933 A004
Maine Turnpike
Authority
additional info

WR**Wright-Ryan Construction Inc**
REQUEST FOR INFORMATION10 Danforth Street
Portland, ME 04101Phone: 207-773-3625
Fax: 207-773-5173No.: 00448
Date: 5/1/2009**TO:** Attn: Scott Benson
SMRT
144 Fore Street
Portland, ME 04101
Phone: 207 772-3846 Fax: 207 772-1070**PROJECT:** MTA Administration Building
JOB: 0721**Subject:** Fire Department Requirements C of O**1. REQUEST:**

From: Scott Benson [SBenson@SMRTInc.com]
Sent: Wednesday, April 29, 2009 7:27 PM
To: Craig Hill
Cc: Charlie Myers; Laurie Warhol; Rick Paulison; Scott Warchol
Subject: RE: MTA - Preliminary Certificate of Occupancy Walk Through

SHEET No. **AE001**  
 © COPYRIGHT 2007 SMT SRT

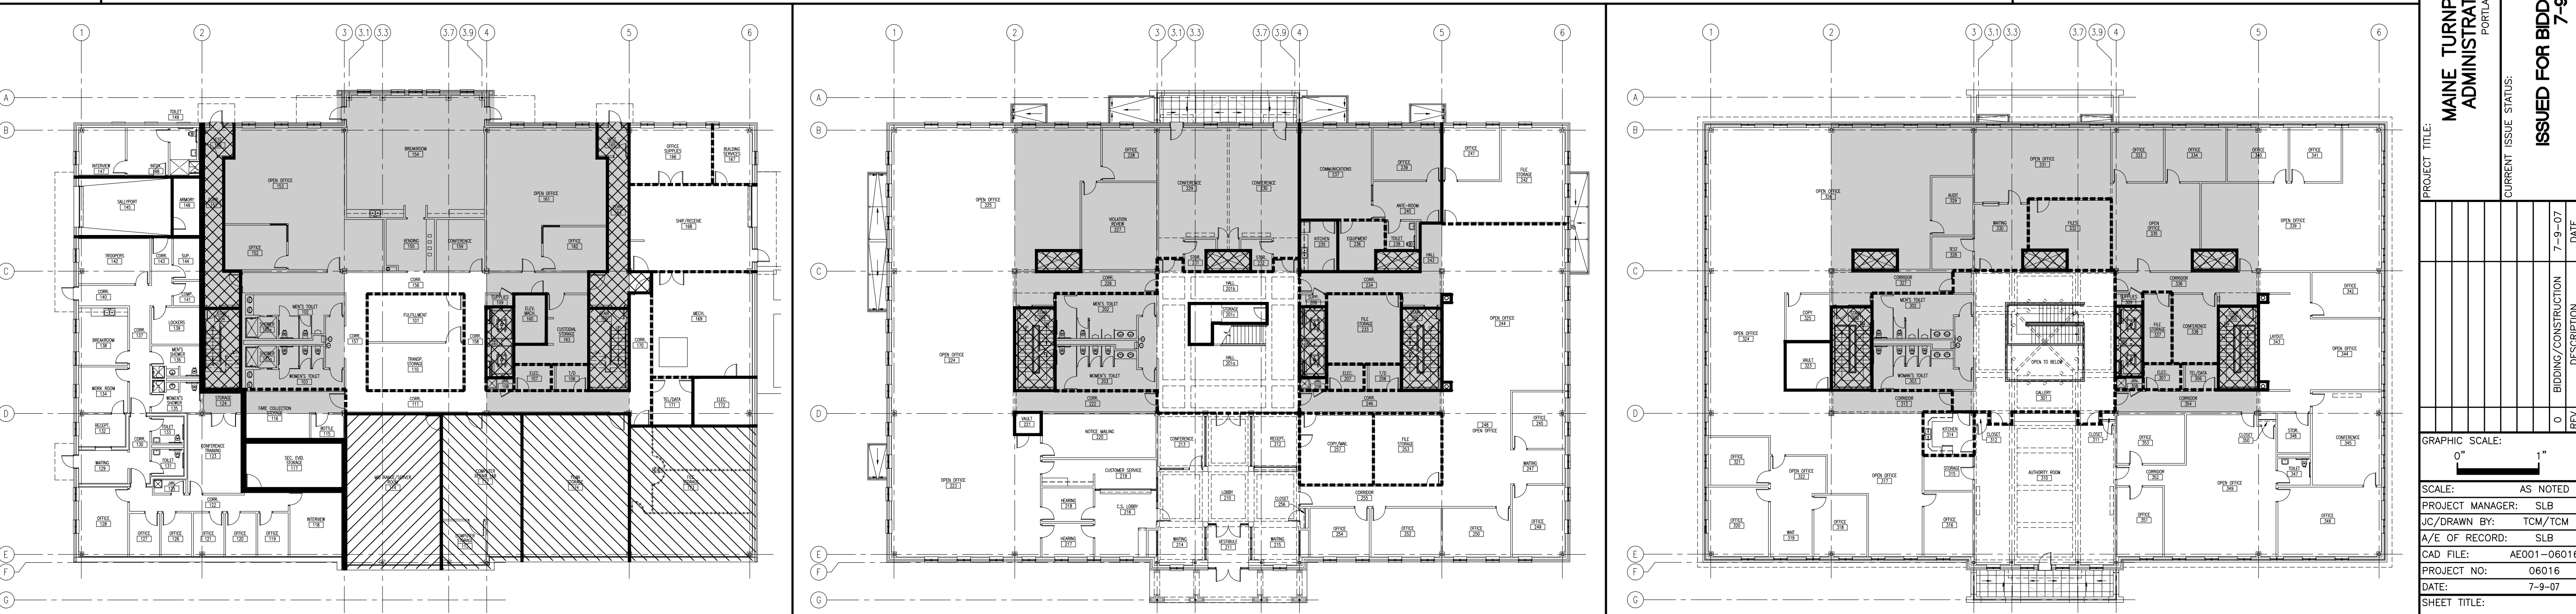
During the certificate of occupancy walk through yesterday 4/30/09 the fire department is requesting a letter of compliance stating which standards were used in the design of the fire alarm systems that would state how it was determined where the strobes, horns, and horn/strobes were placed and why there were rooms without devices. Issues that brought this up included the following items.

- Room 346 does not have any fire alarm device in it
- Office 344 has limited visibilty to the strobe in the hallway
- Office 317 (new office created by SI #96) only has a strobe in it.
- Rooms 318, 320, and 321 and the gang bathrooms they would like audibility tests done to make sure those rooms will hear the proper level required for the horn outside these rooms.

Applicable standards are those identified in the contract drawings on sheet AE001.

- Room 346 is a private office not presently subject to occupancy by a hearing impaired person, not a public area, and not required to be equipped with visual notification per NFPA101/9.6.4.5.2.
- Room 344 is an office and subject to the same provisions as apply to room 346.
- The visible device in room 317 may be swapped with the audible device in corridor 313.
- Please coordinate with the City, and perform the audibility test requested.
